**Planning Department
Transportation Development Services**

May 22, 2015

**Re: Gordon Warehouse
8508 Constitution NE
Traffic Circulation Layout**
Engineer's/Architect's Stamp dated 5-8-15 (J20-D037A)

Grading & Drainage
Plan W/ TCL Elements

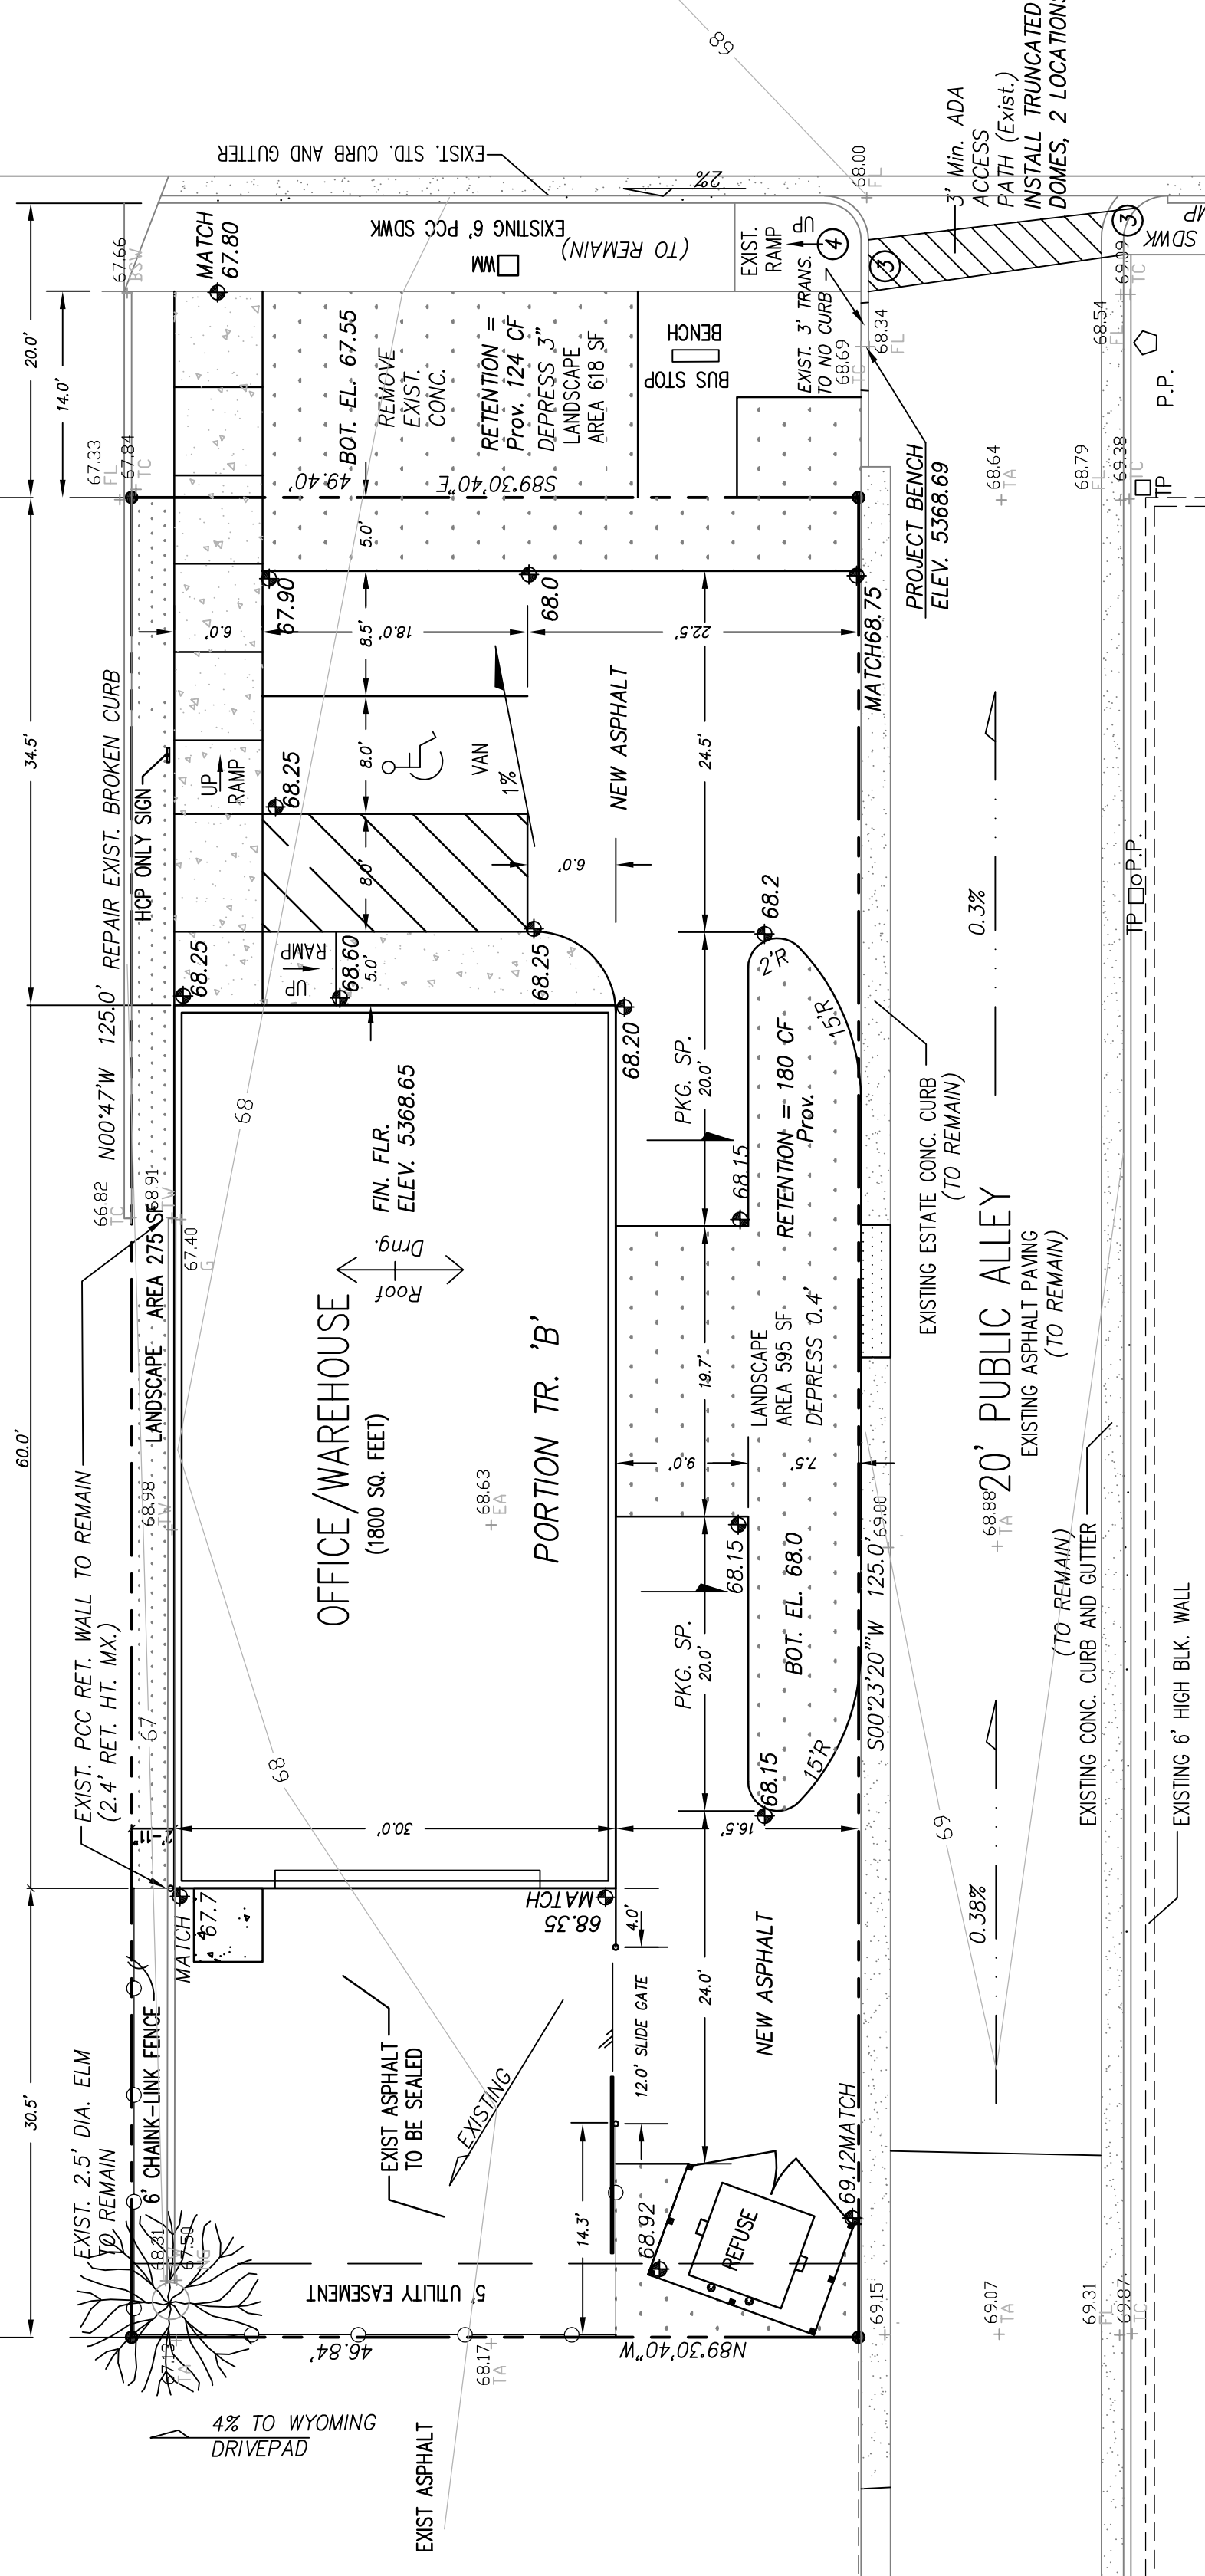
1. A scale of 1"=20' is recommended for sites less than 5 acres.
2. Please provide a separate TCL Site Plan, separate from Drainage Plan.
3. Please provide a Legend notation for Landscaping. It is hard to differentiate the landscaping notation from the cement notation.

4. Please identify all buildings, doors, structures, sidewalks, curbs, drive pads, walls and anything that influences the parking and circulation on the site.

5. Identify all existing access easements and rights of way with dimensions.
6. Identify the right of way width, medians, curb cuts, and street widths on both Constitution Ave. and the Public Alley.

7. Please review the regular and ADA parking on the northeast corner of the proposed building. There does not seem to be enough of a turning radius for the ADA parking customers backing out of the ADA parking without backing up into the Public Alley. Please consider moving the regular parking space at the northeast corner further south or to another location. Please provide a Turning Template Analysis and Exhibit on the resubmittal.

8. Please call out slope (12:1 Max) of ADA pedestrian pathway and provide a detail.
9. Please provide detail of truncated domes on the sidewalk at the intersection of Constitution Ave. and the Pubic Alley.

10. The handicap accessible spaces must be a minimum of 8.5 feet in width.

11. The handicap accessible spaces must include an 8-foot wide van access aisle; all other aisles should be 5 feet in width.
12. The ADA van accessible sign must have the required language per 66-7-352.4C NMSA 1978 **"Violators Are Subject to a Fine and/or Towing."**

13. The ADA access aisle shall have the words **"NO PARKING"** in capital letters, each of which shall be at least one foot high and at least two inches wide, placed at the rear of the parking space so as to be close to where an adjacent vehicle's rear tire would be placed. (66-1-4.1.B NMSA 1978)

14. Show all drive aisle widths and radii.
15. List radii for all curves shown; for passenger vehicles, the minimum end island radius is 15 feet. Landscape island radius for delivery trucks, fire trucks, etc. is 25 feet or larger

16. A five-foot keyway is required for dead-end parking aisles. This is applicable to the ADA Handicap parking spaces shown on the proposed plan.
17. Per the DPM, a 6 ft. wide ADA accessible pedestrian pathway is required from the public sidewalk to the building entrances. Please clearly show this pedestrian pathway and ramps and provide details.

18. Per the DPM, a 6 ft. wide ADA accessible pedestrian pathway is required from the HC parking stall access aisles to the building entrances. Please clearly detail HC pathway access aisles.

19. Provide a min 6" or max 8" high concrete barrier curb or other acceptable barrier between landscaping and parking areas and/or drive aisles.
20. Design delivery vehicle route needs to be shown.

21. Service vehicle and/or refuse vehicle maneuvering must be contained on-site; provide a copy of refuse approval (if applicable).
22. Please provide a sight distance exhibit (see the *Development Process Manual, Chapter 23, Section 3, Part D.5 Intersection Sight Distance*).

23. Please add the following note to the clear sight triangle: "Landscaping and signage will not interfere with clear sight requirements. Therefore, signs, walls, trees, and shrubbery between 3 and 8 feet tall (as measured from the gutter pan) will not be acceptable in this area."

24. Please specify the City Standard Drawing Number when applicable. Please call out Standard Numbers for ramps and sidewalks.
25. Please include a copy of your shared access agreement with the adjacent property owner.

28. Unused curb cuts must be replaced with sidewalk and curb & gutter. A build note must be provided referring to the appropriate City Standard.
29. Please include two copies of the traffic circulation layout at the next submittal.
